Application for a non-material amendment following a grant of planning permission.

CONVERSION OF EXISTING BEDROOMS  
INTO FLATLETS, INCLUDING CHANGE OF  
GROUND FLOOR WINDOWS TO WINDOWS  
& DOORS.

ADDITIONAL WINDOWS CHANGED  
TO DOORS WITH WINDOW TO SIDE.

scale	date	job no	drg no	A
1:100 @ A1	12/10	1323	21

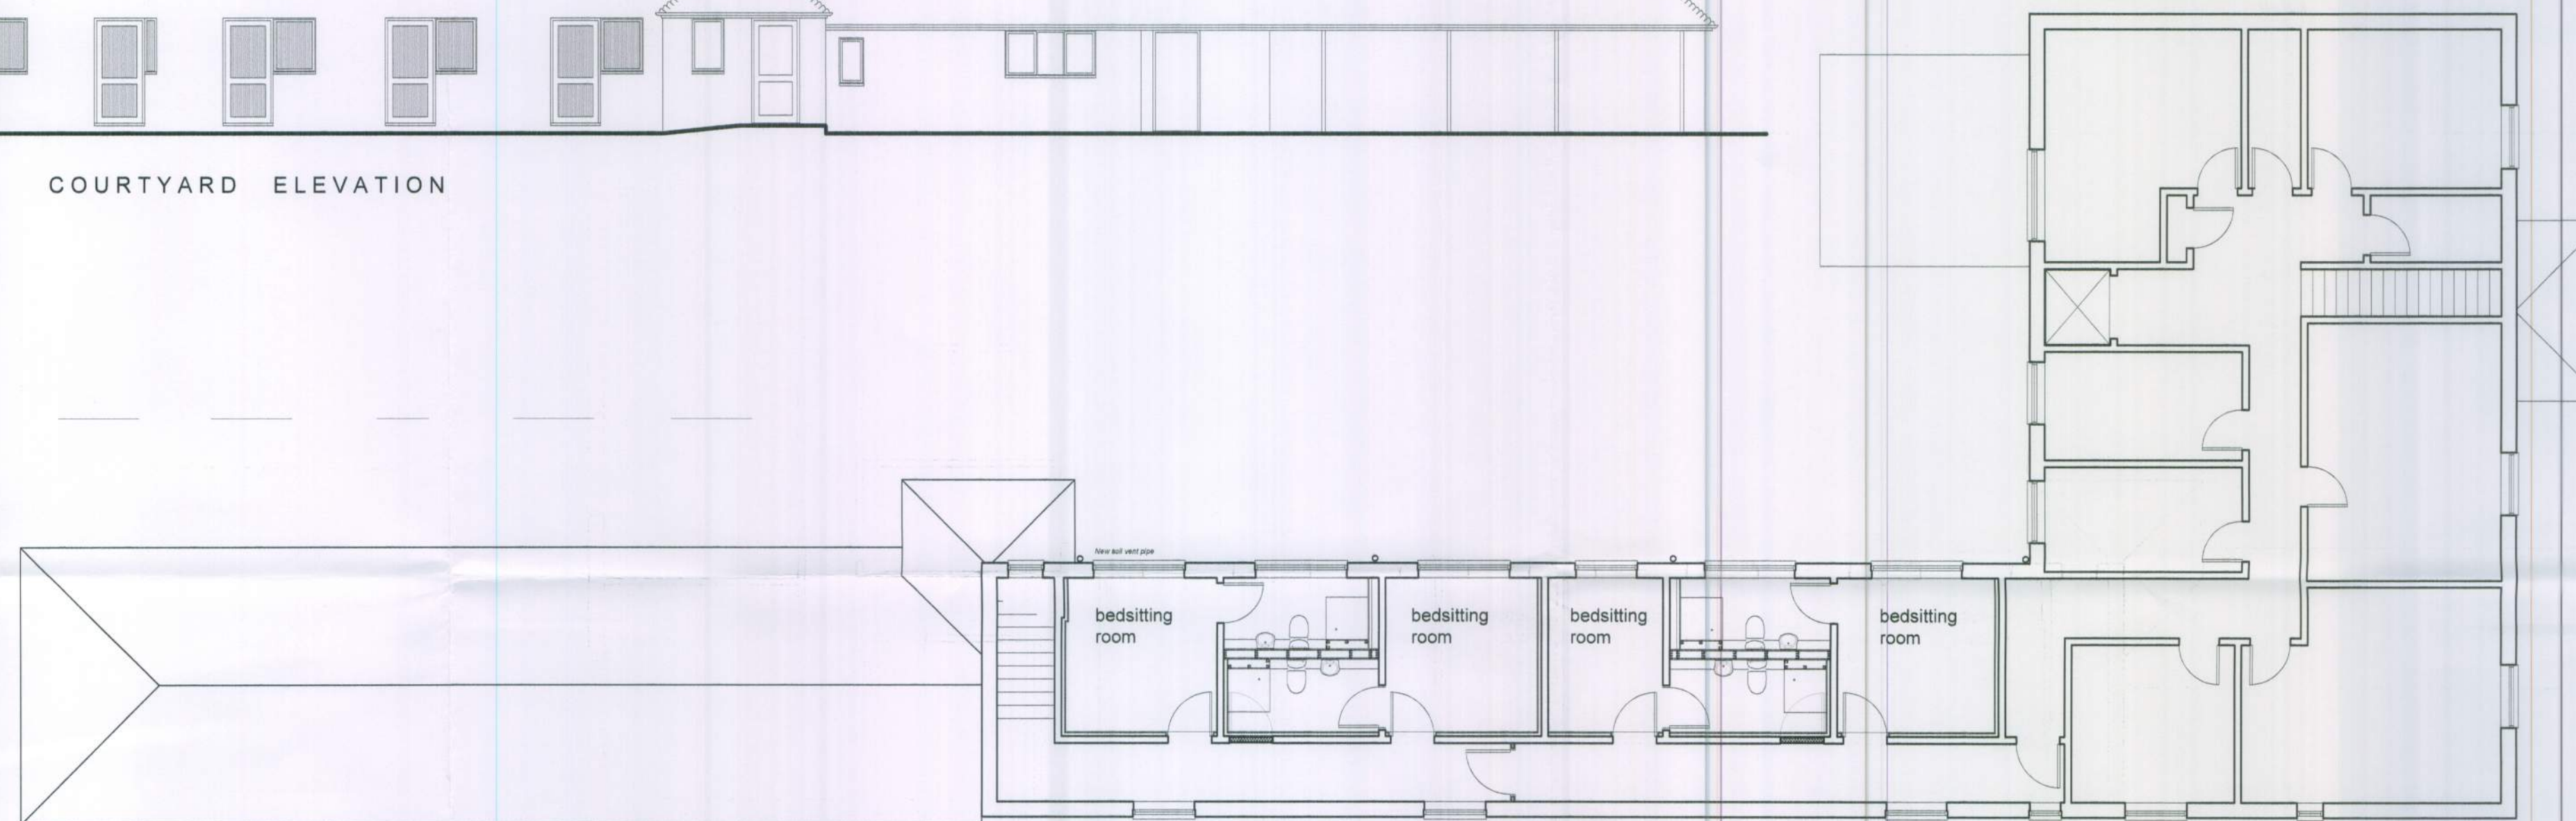
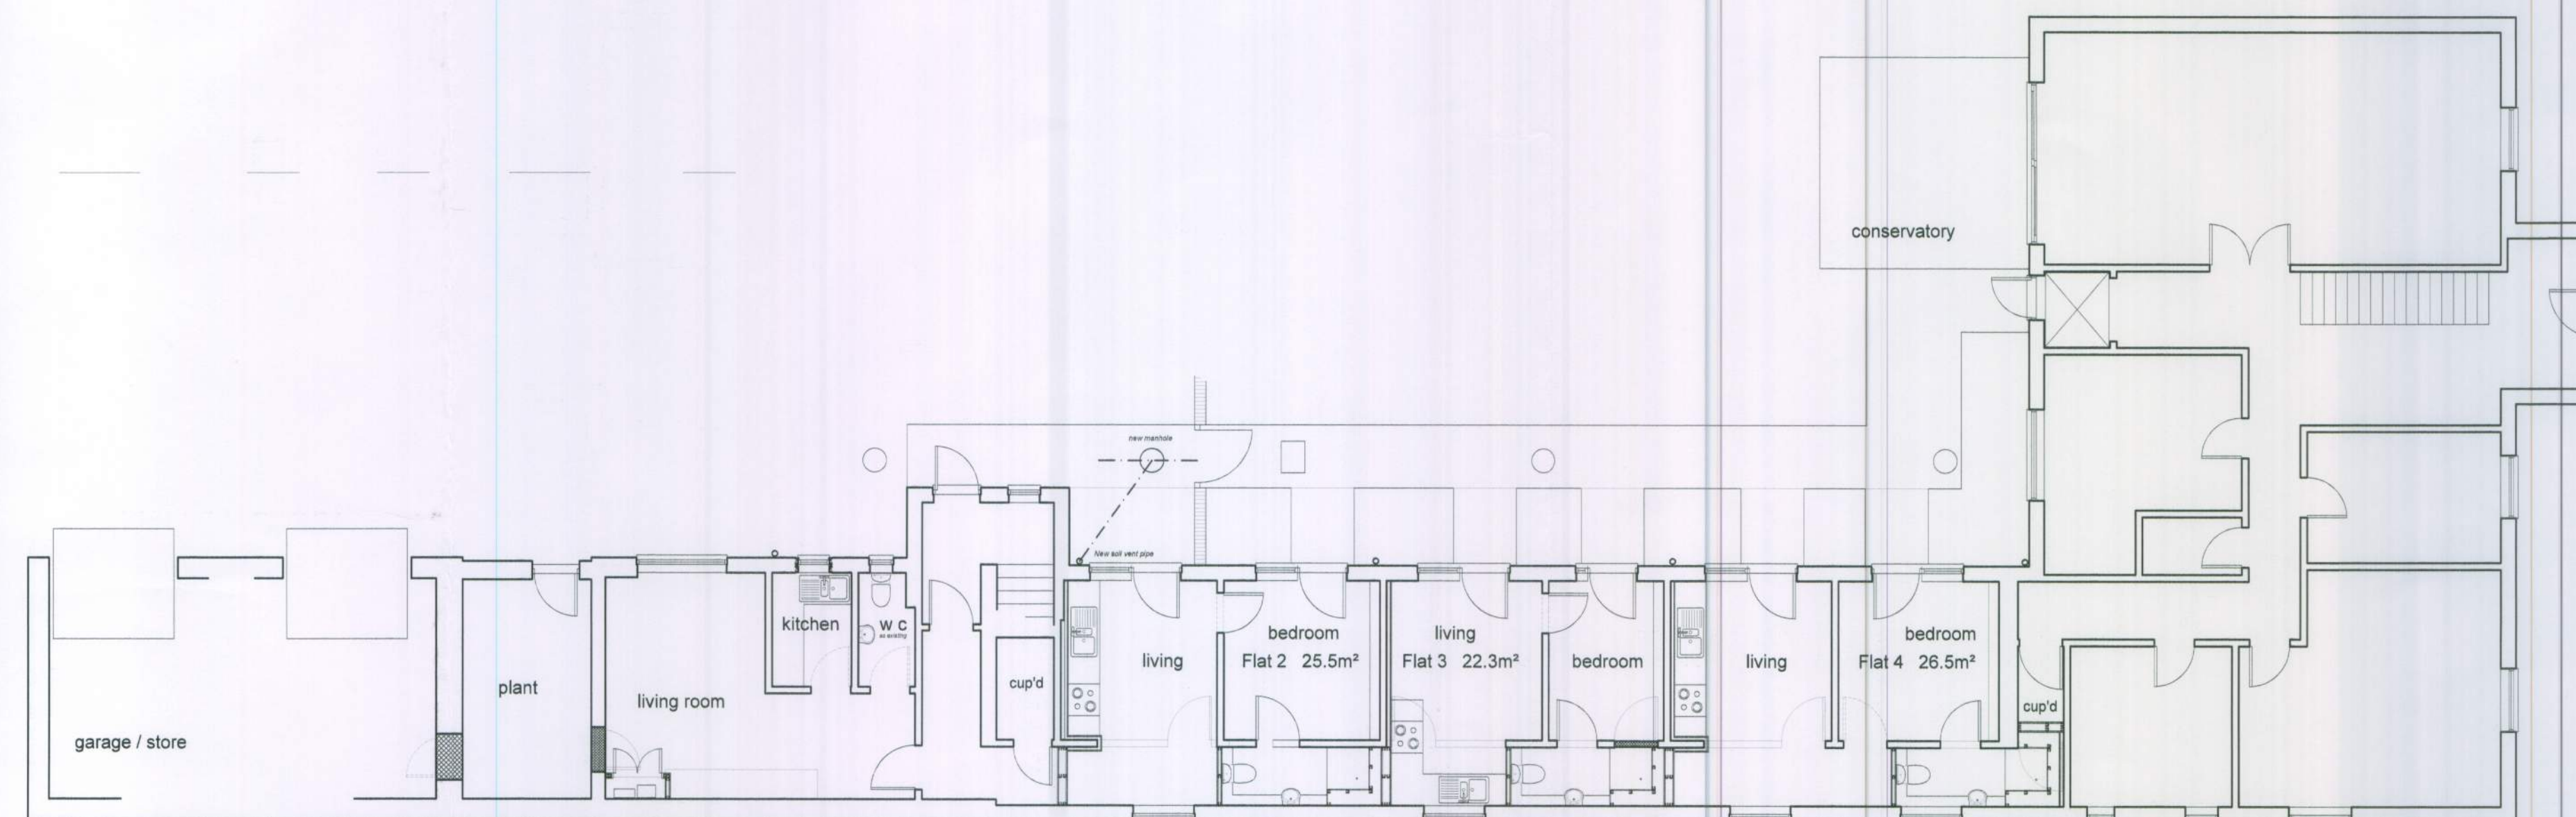
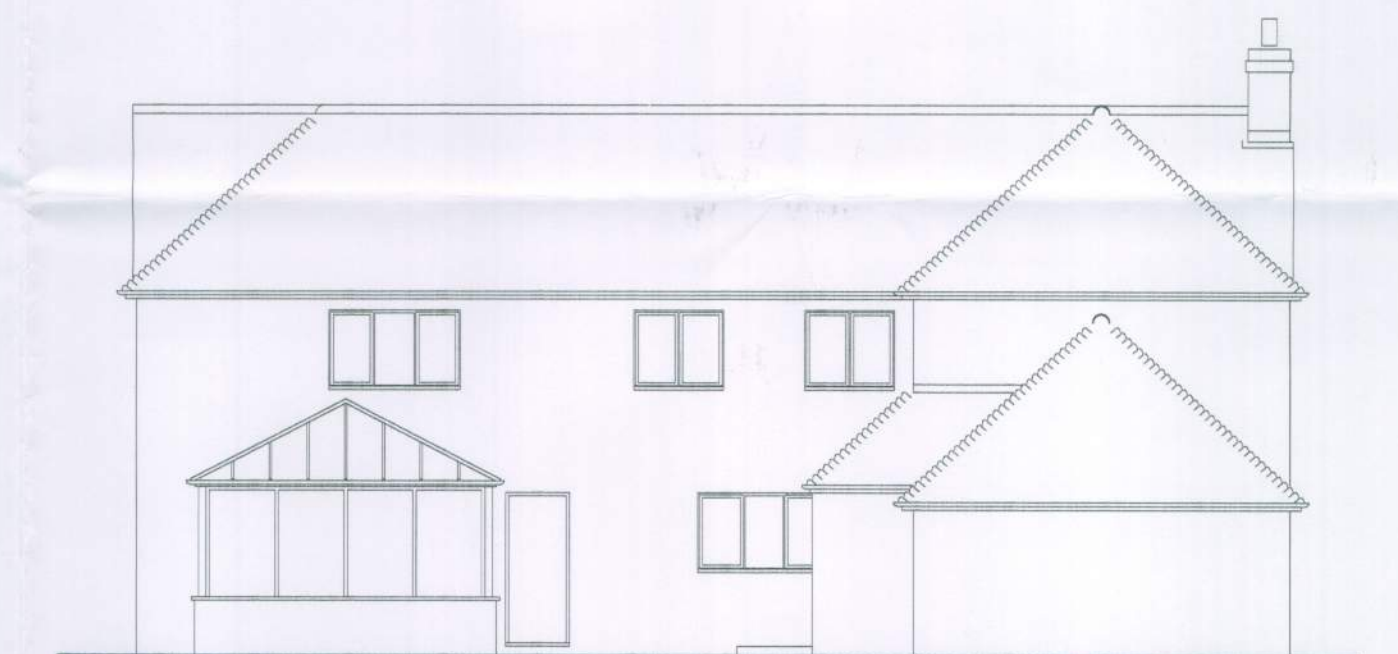
CHANGES ARE DUE TO BUILDING REGULATION / FIRE ESCAPE  
REQUIREMENTS IMPOSED BY BUILDING INSPECTOR.
